PLANNING DEPARTMENT
July 15, 2015
DRB Comments

PROJECT # 1010532

APPLICATION # 15-70242

RE: Lots 1-5, Block 2, City Realty Co. Addition No. 1

PROJECT: 1010532
DATE: 7/15/15
APP: 15-70242(SK)

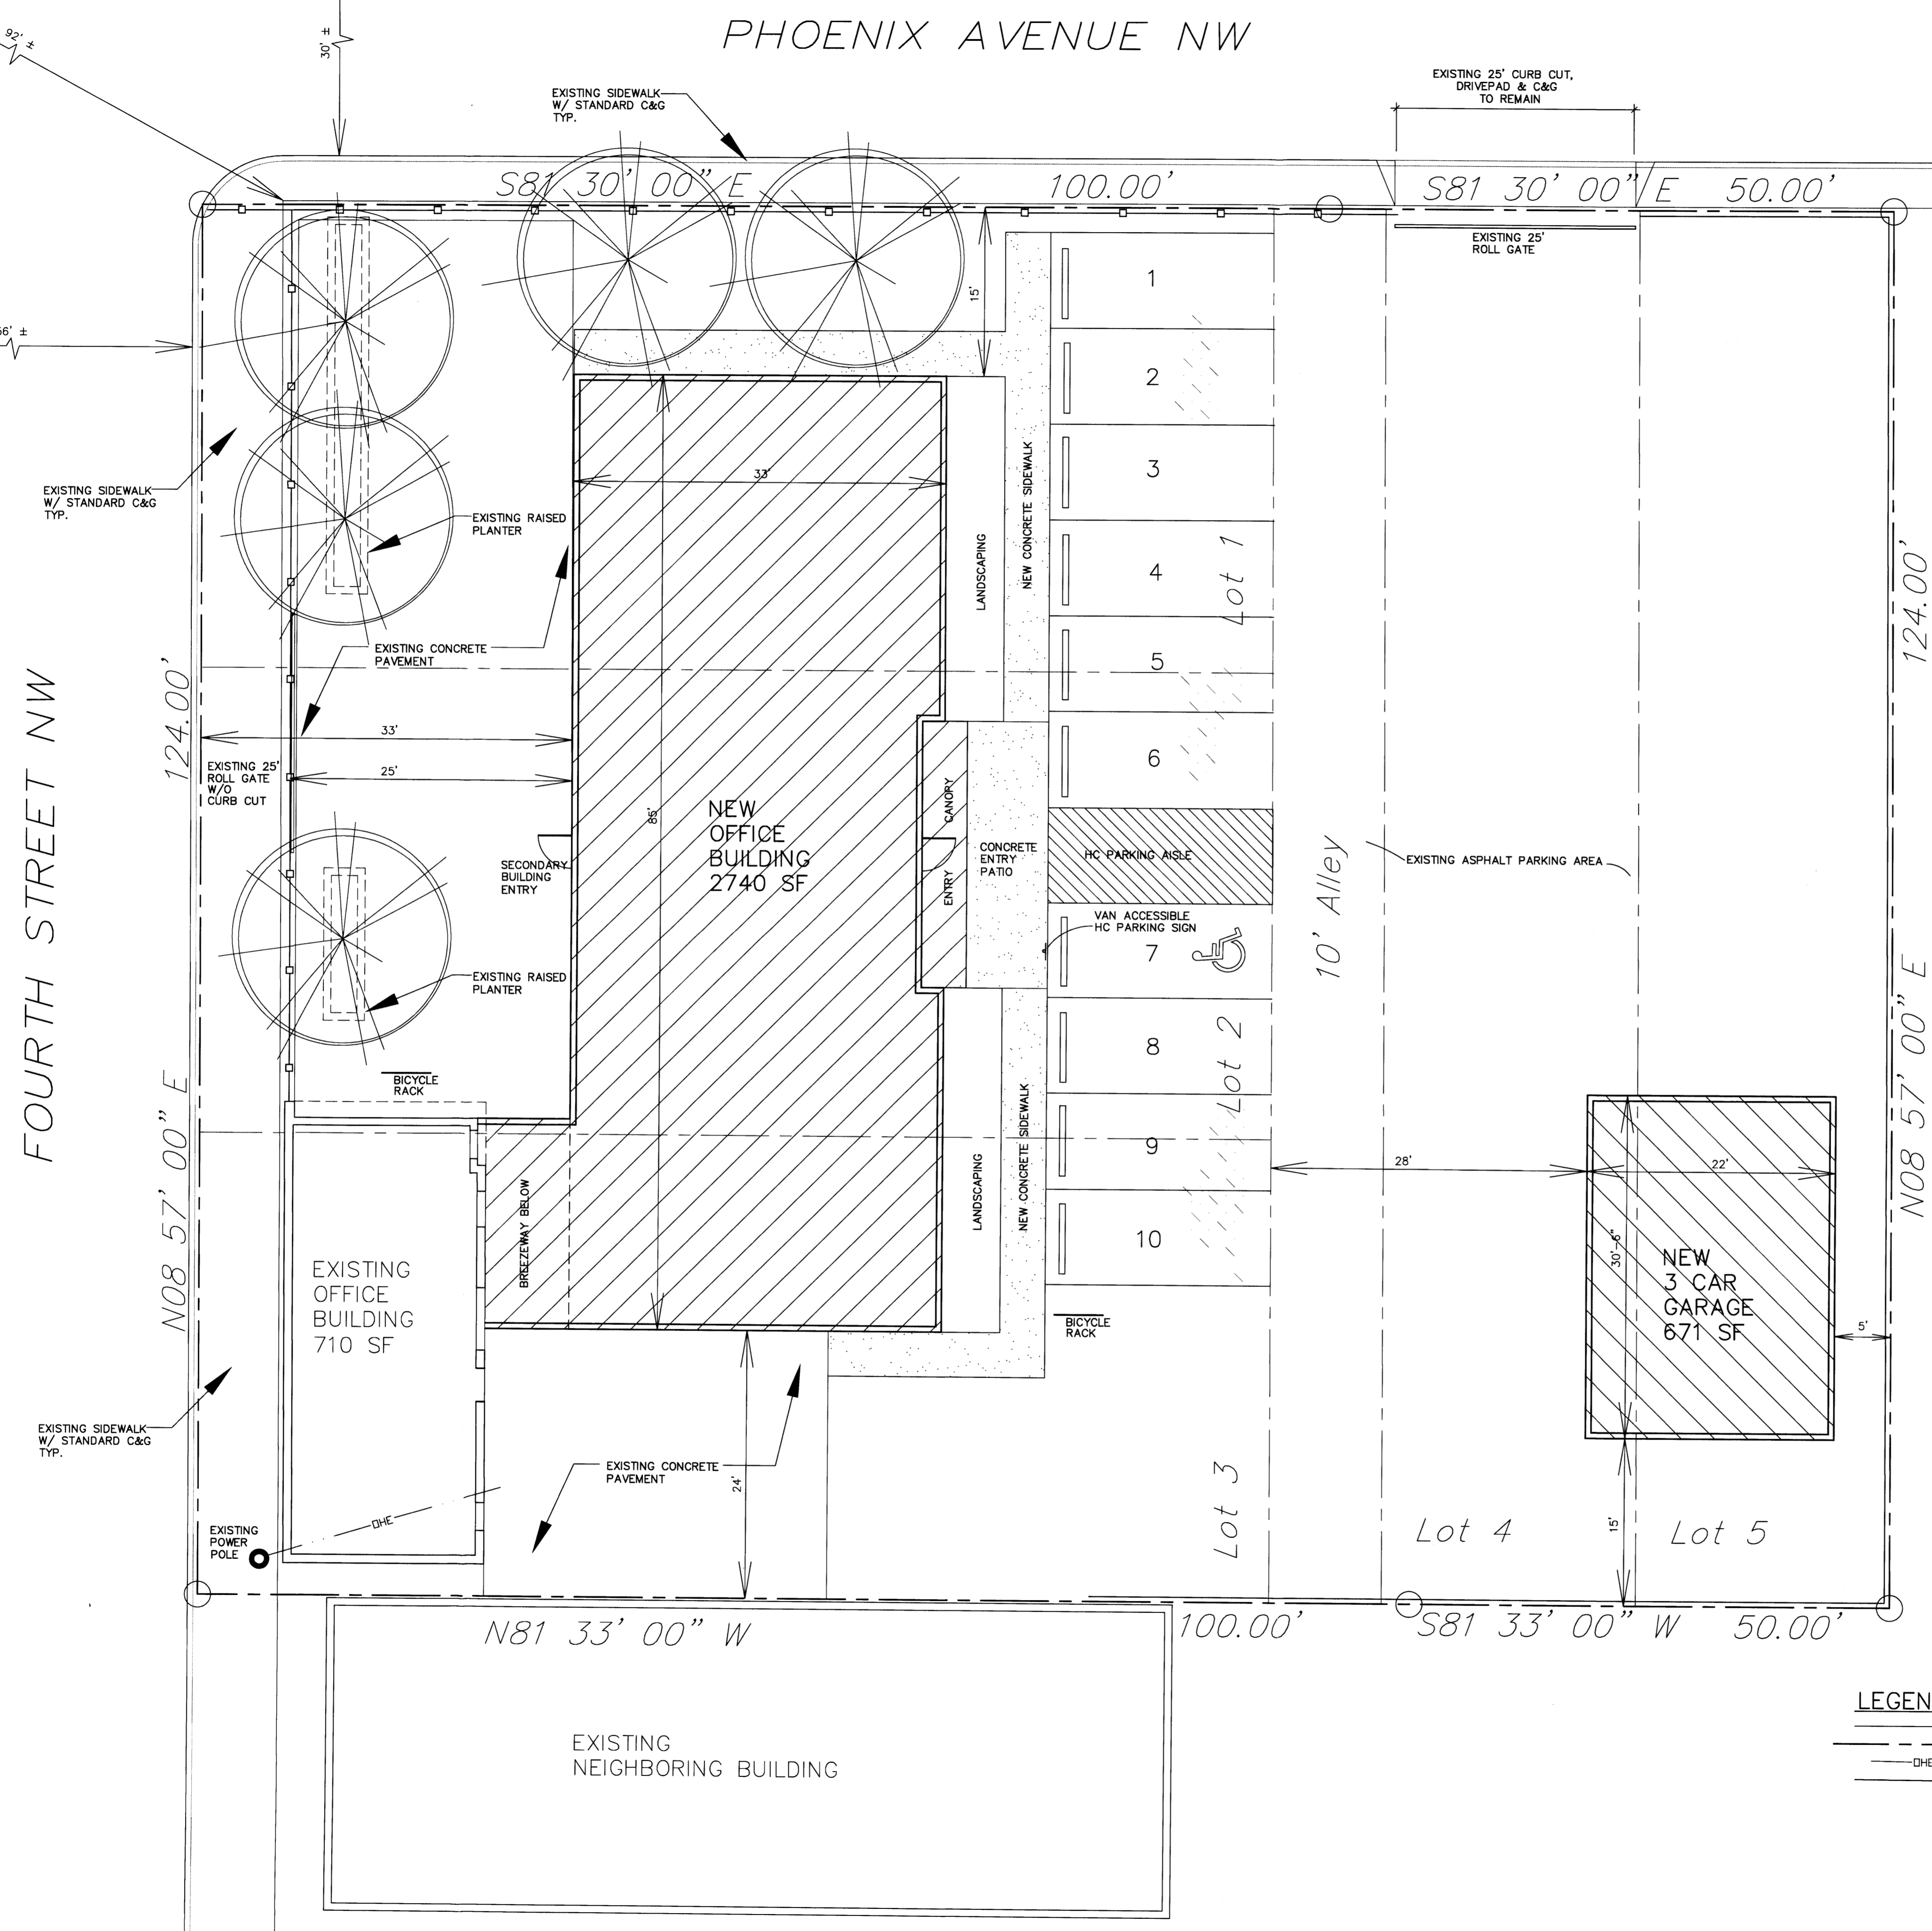
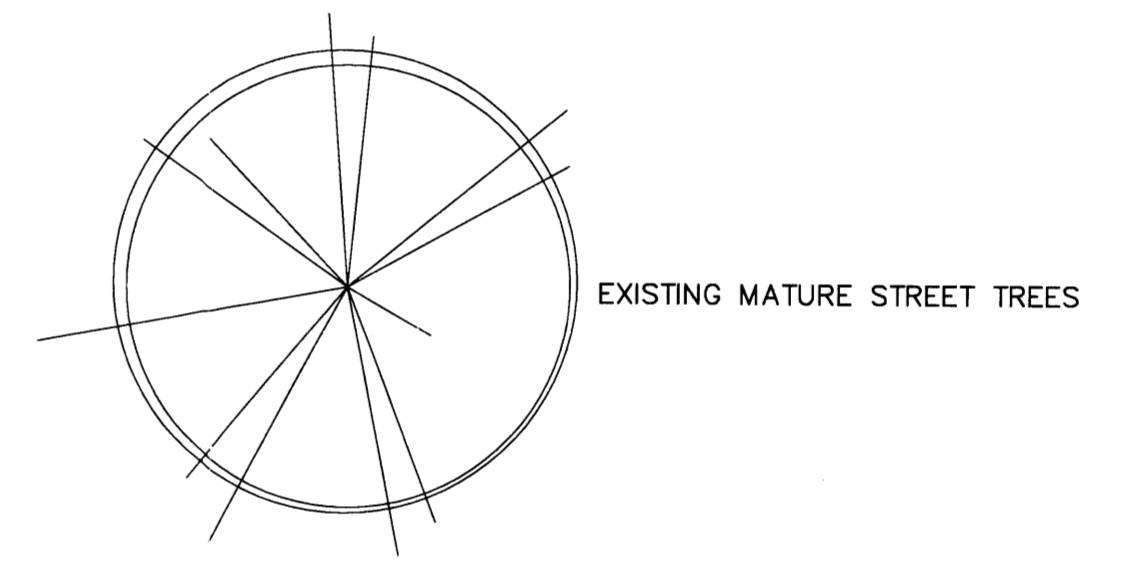
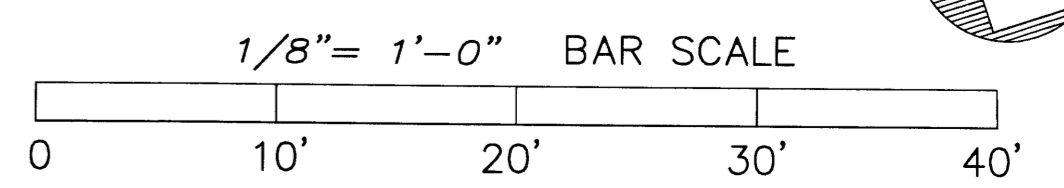
Lots 4 and 5 are zoned R-1 per the City's Geographic Information system (GIS) and cannot be used as a parking lot for commercial uses; a zone change would be needed.

The alley should be vacated, acquired and replatted into adjacent property; City Council approval of the vacation would be required after a public hearing and recommendation by DRB.
